# CDR20002-R1-CD-redlines Summary\_Markup Summary

CDR-20-002

COVER SHEET

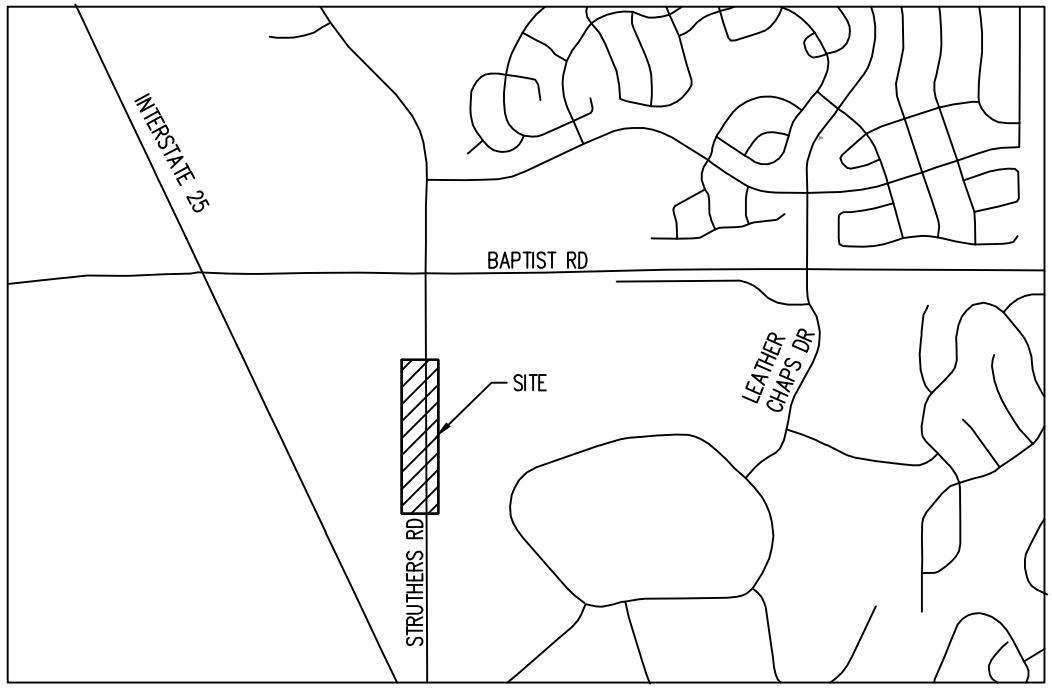
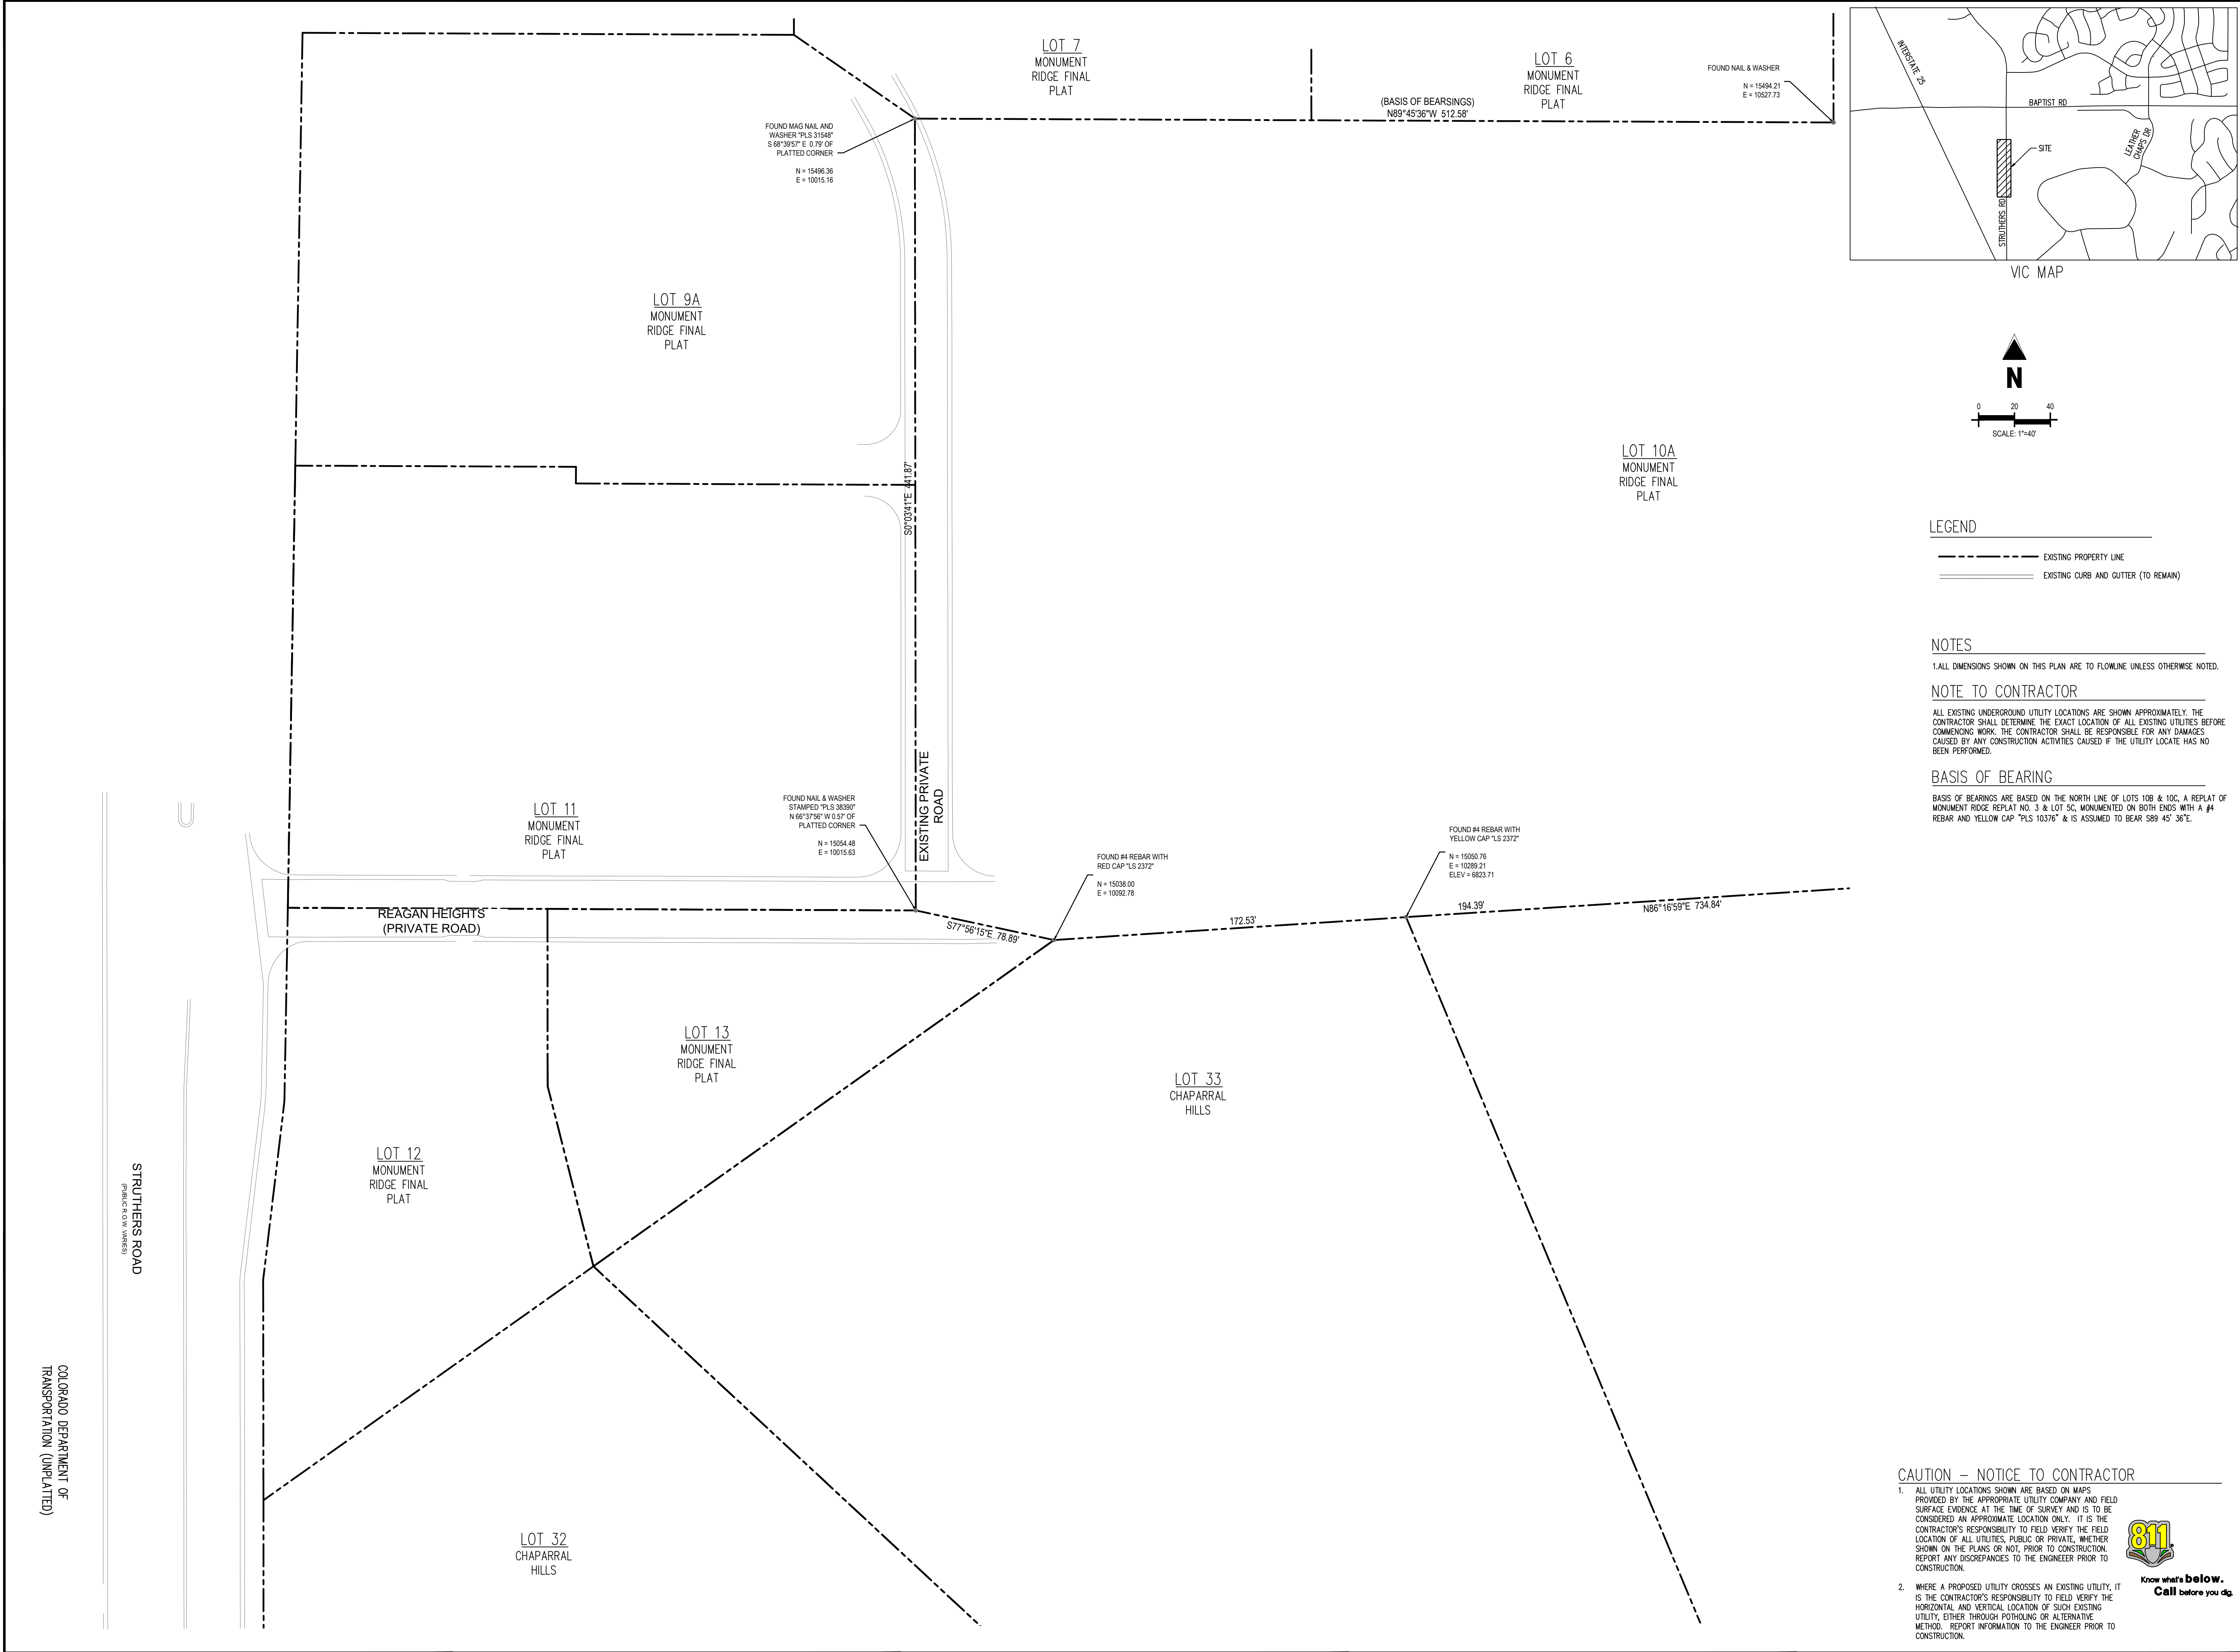
Use CD signature blocks

Is this correct?

PCD

Is this right?

DPW REQUIREMENTS

Provide contact info for:  
CDOT (if this is their ROW)  
Town of Monument:  
EPC PCD  
EPC DPW  
Fire district  
(If affected, utility districts)

Provide cross-sections

Callout before you dig

DEMO PLAN

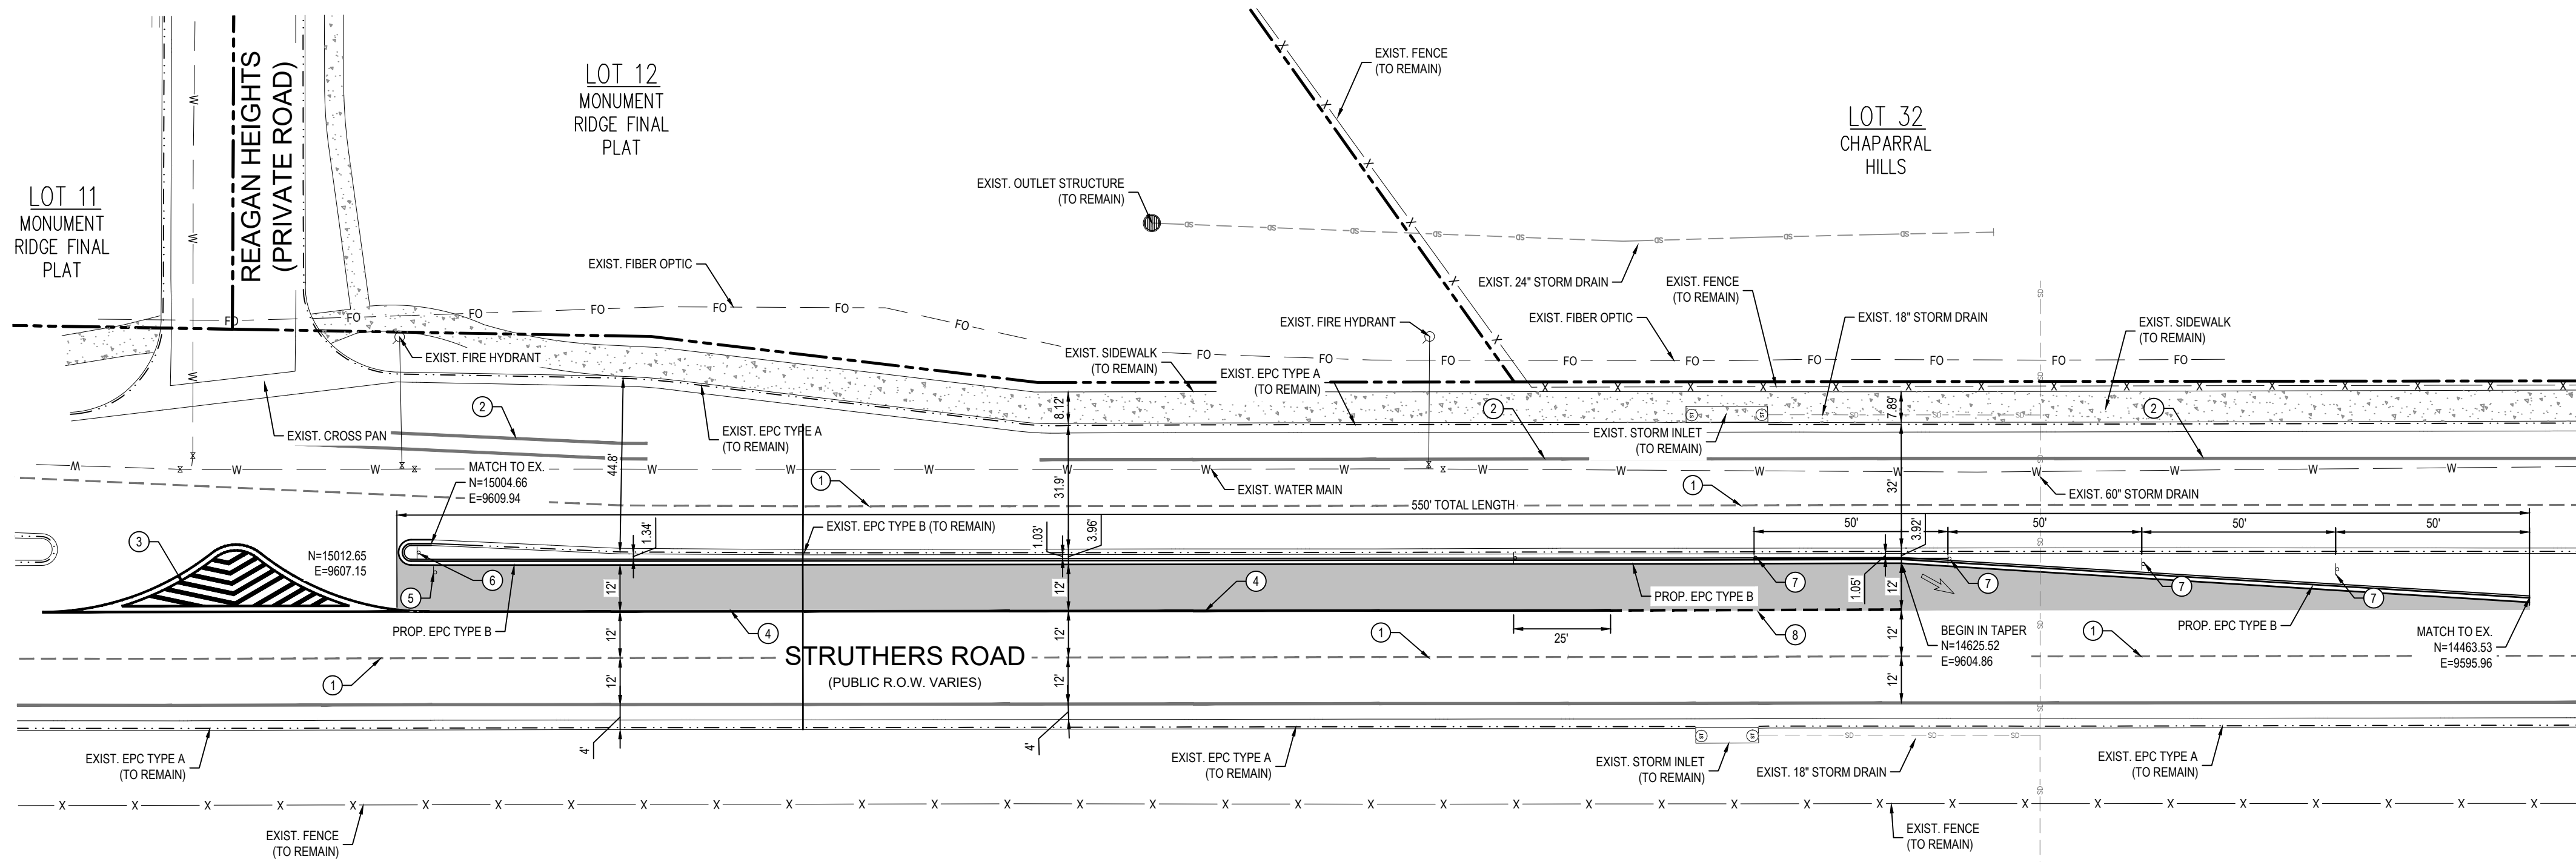
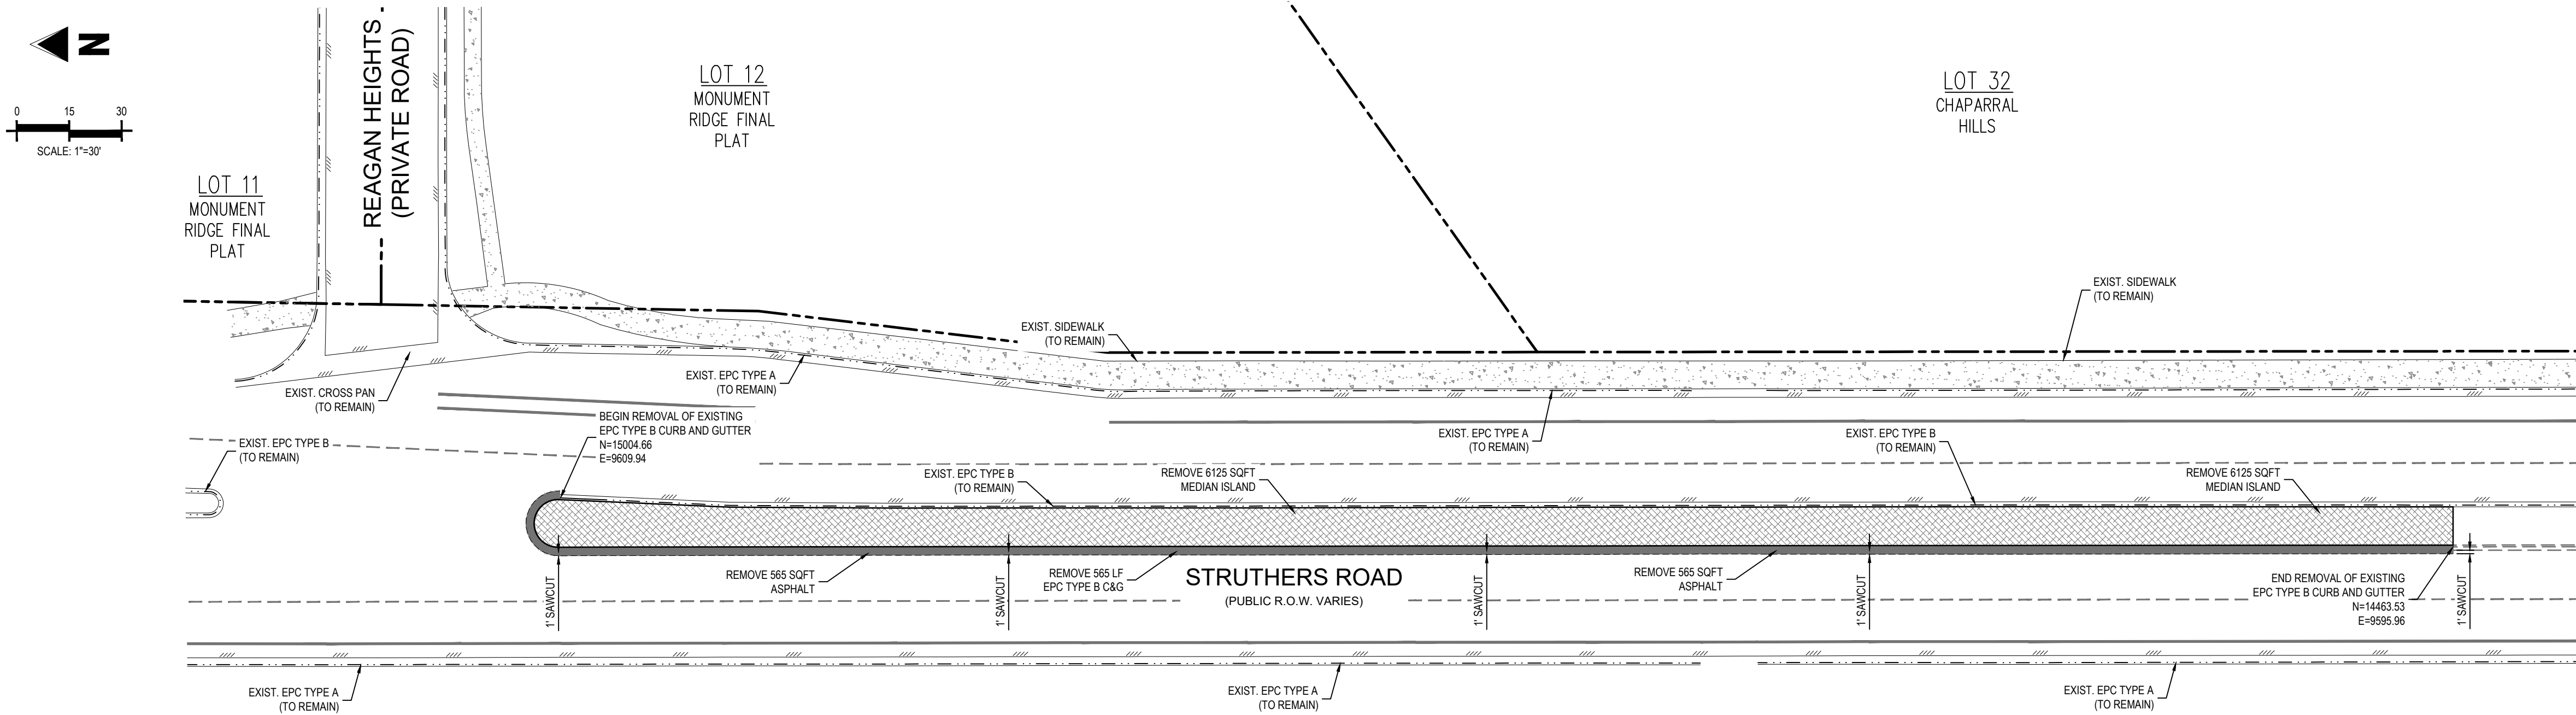
Delete

Not needed next to curb

Asphalt width should be 12'

Dotted?

Provide bearing and distance ties to survey control points with description and coordinates.

Provide bearing and distance ties to survey control points with description and coordinates.
